From: Nick Scott [REDACTED]
Sent: 15 January 2014 13:53
To: Cian Cronin
Cc: Katrina Harper
Subject: Comments further to Planning Application. Ref: Y/87/13 (Installation of solar farm on land south west of Drove Lane Farm) FP155

Further to a recent email from Adrian Hunter regarding the above named planning application I am responding with comments from the public rights of way team within WSCC.

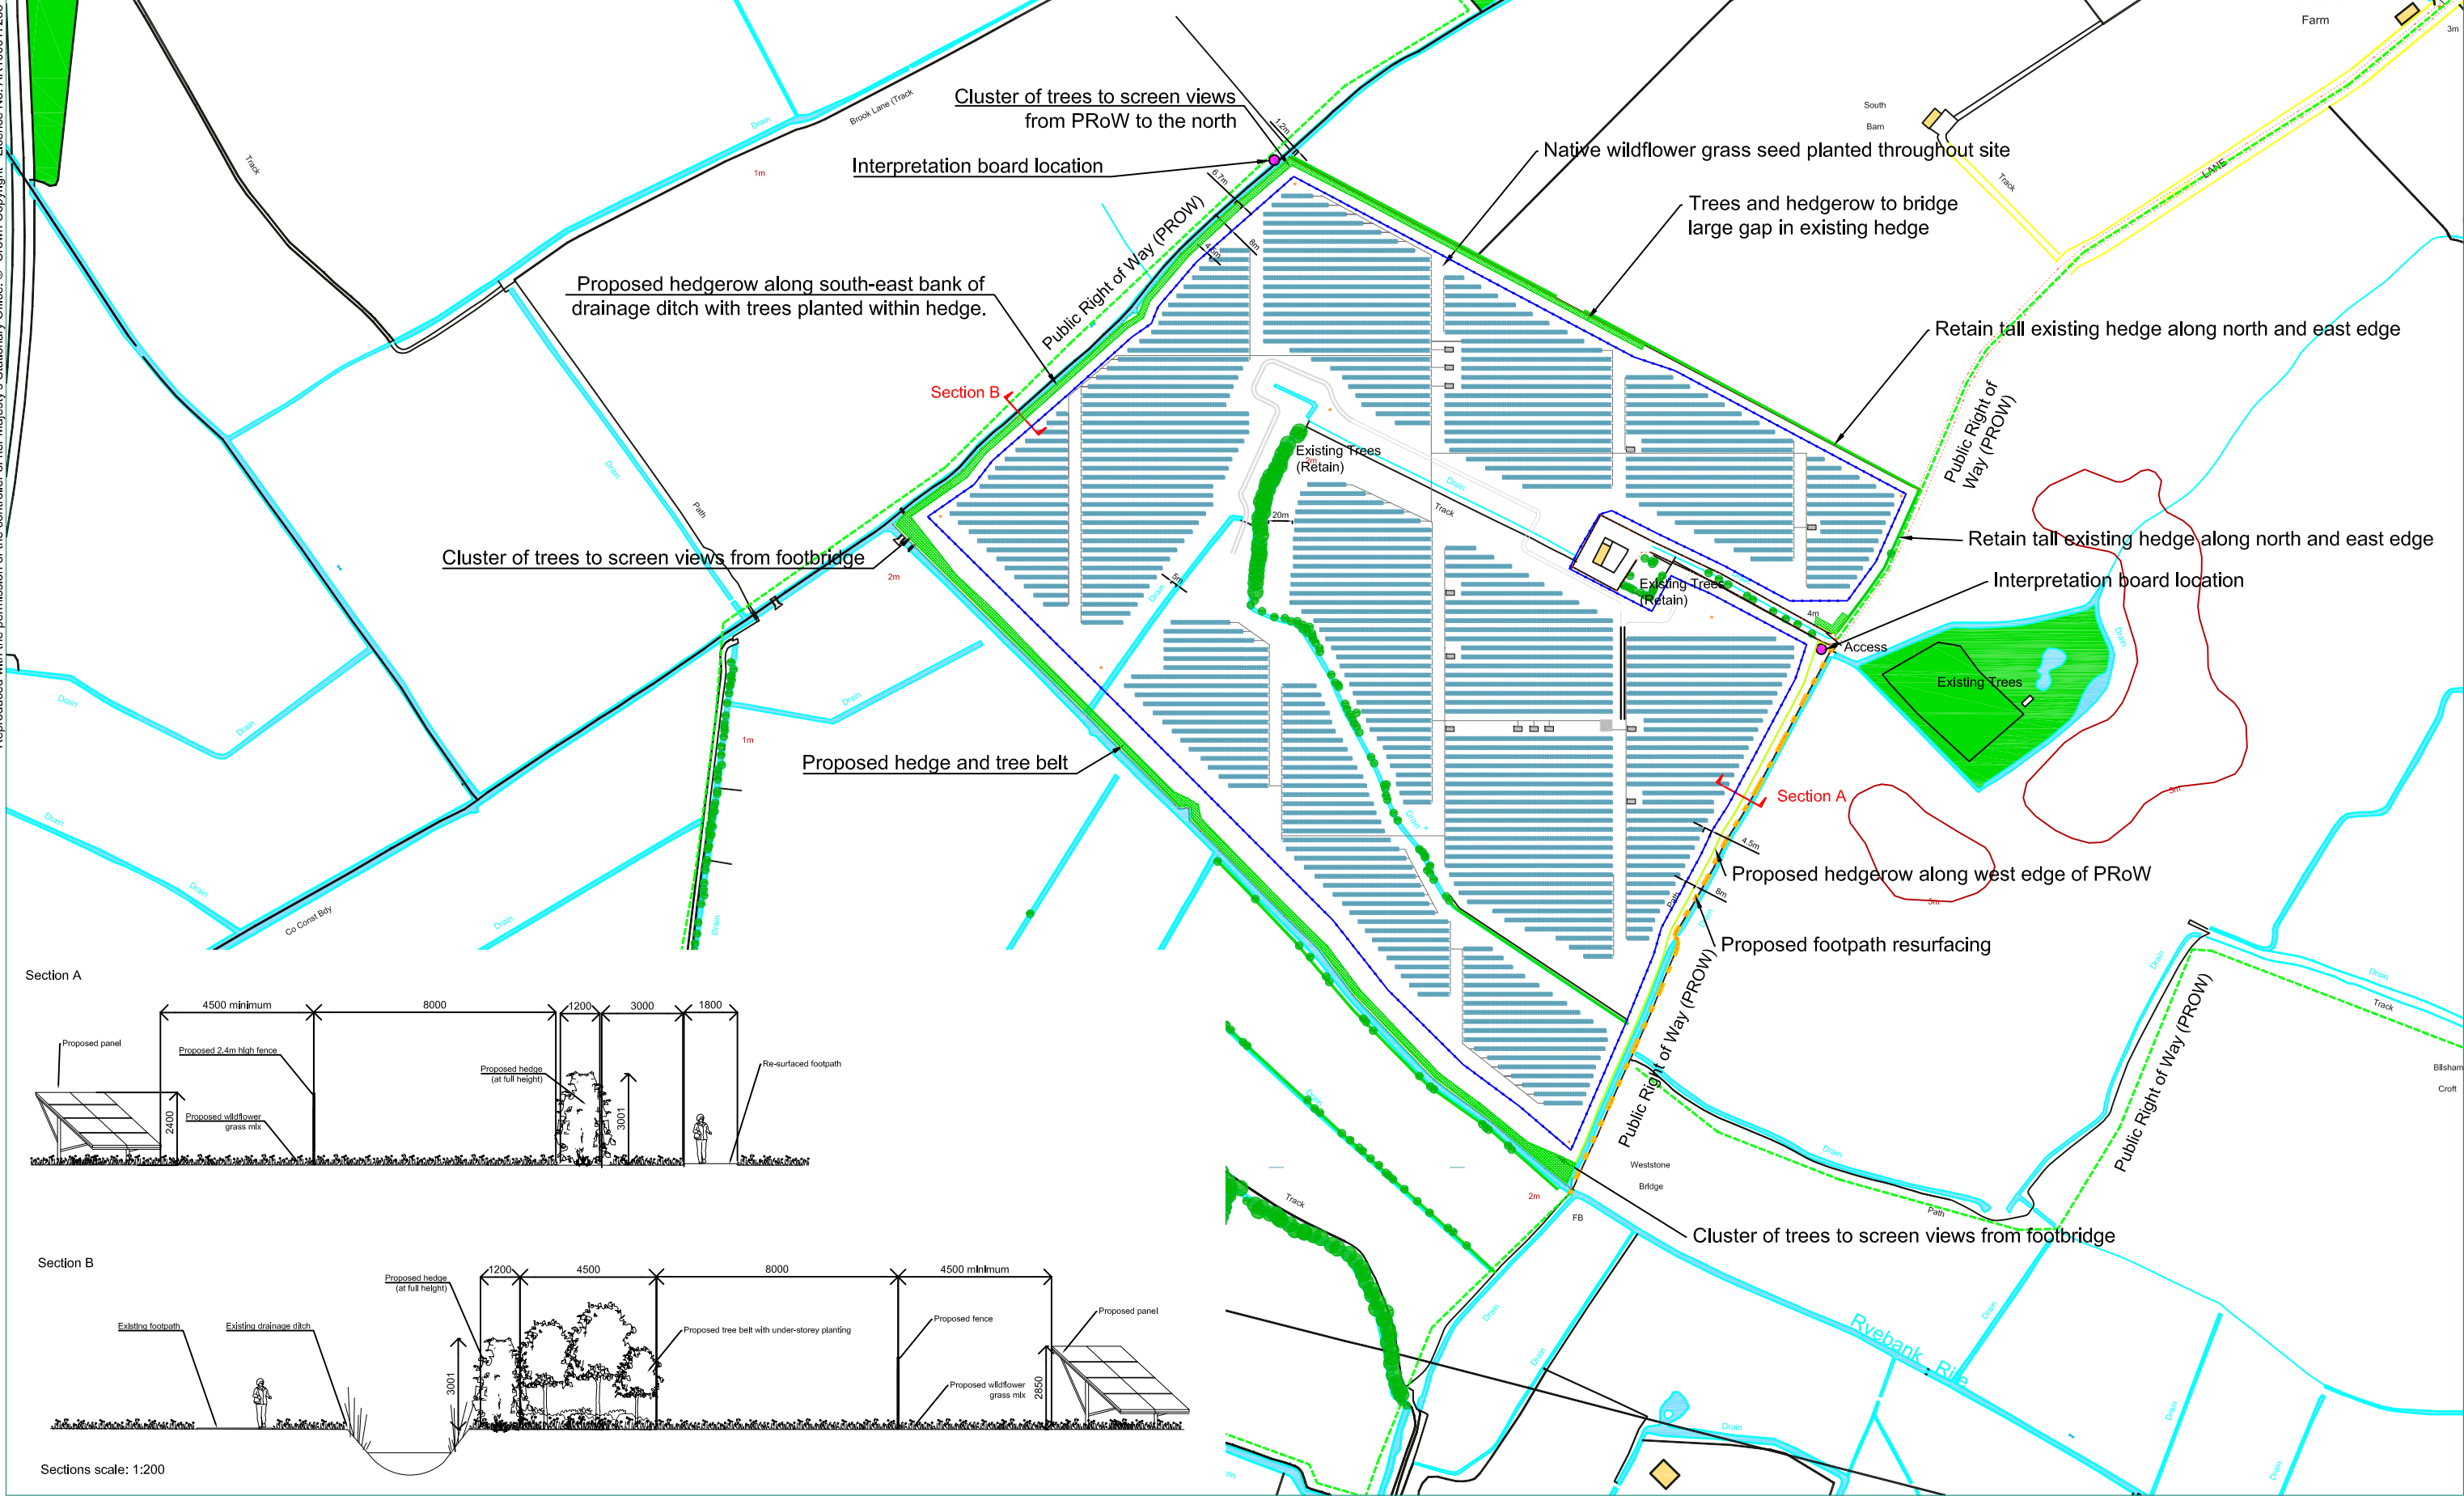
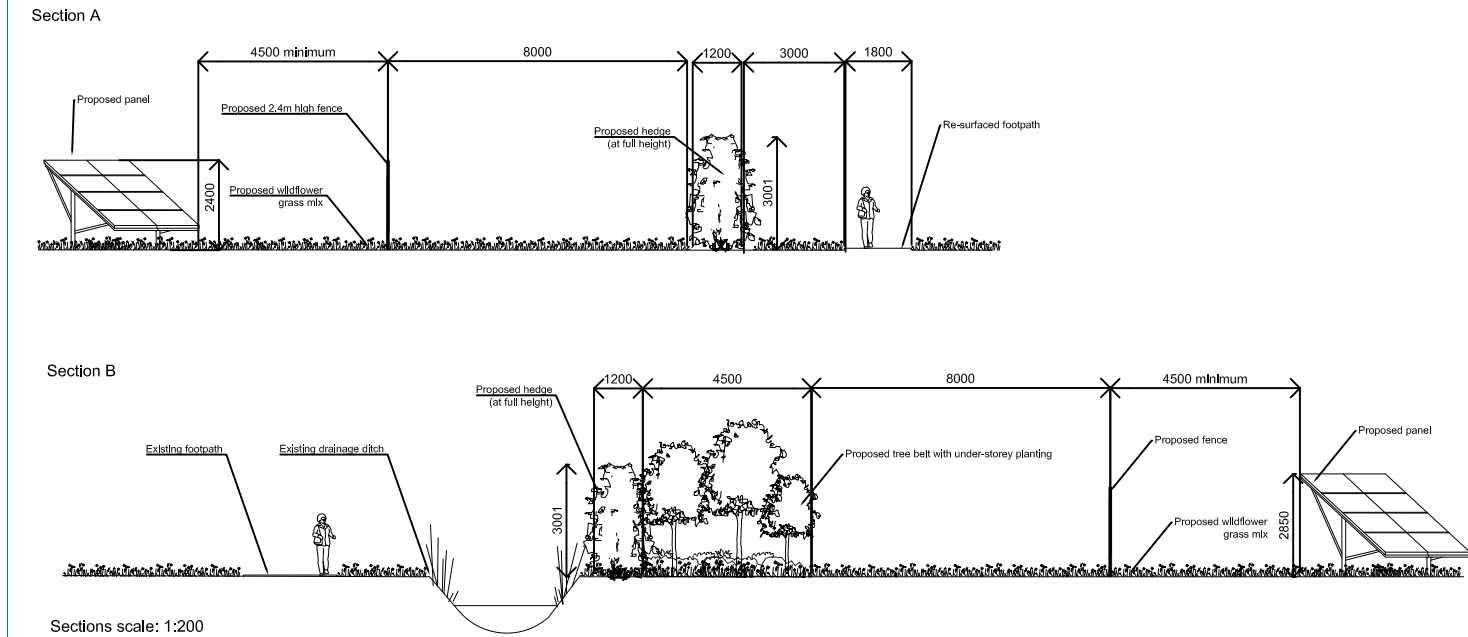
Finally on Drawing No. 2563_101_REV F it is shown that footpath resurfacing is proposed for the section south, from the vehicular access into the site opposite the "existing trees", south to the Ryebank Rife. This of course would be a benefit to the existing route as I have been informed that this is currently an unmade surface. There is no specific legal width reported for this stretch of footpath but I would ask for a minimum useable width of 2m to made available to accommodate the public right of pedestrian access and ideally a rolled stone surface to be laid to a specification agreed with WSCC prior to works beginning. The only other point I wish to make on this is that the legal line is shown to run south from the access into the site on the western side of a ditch and then crosses over to the eastern side of this ditch approximately half way down toward the Ryebank Rife. I am still awaiting confirmation of this from the local access ranger for the area which she should be able to confirm later next week. If it does cross over then there may be issues with the current structure however I will update you on this at my nearest convenience after my colleague has visited the site.
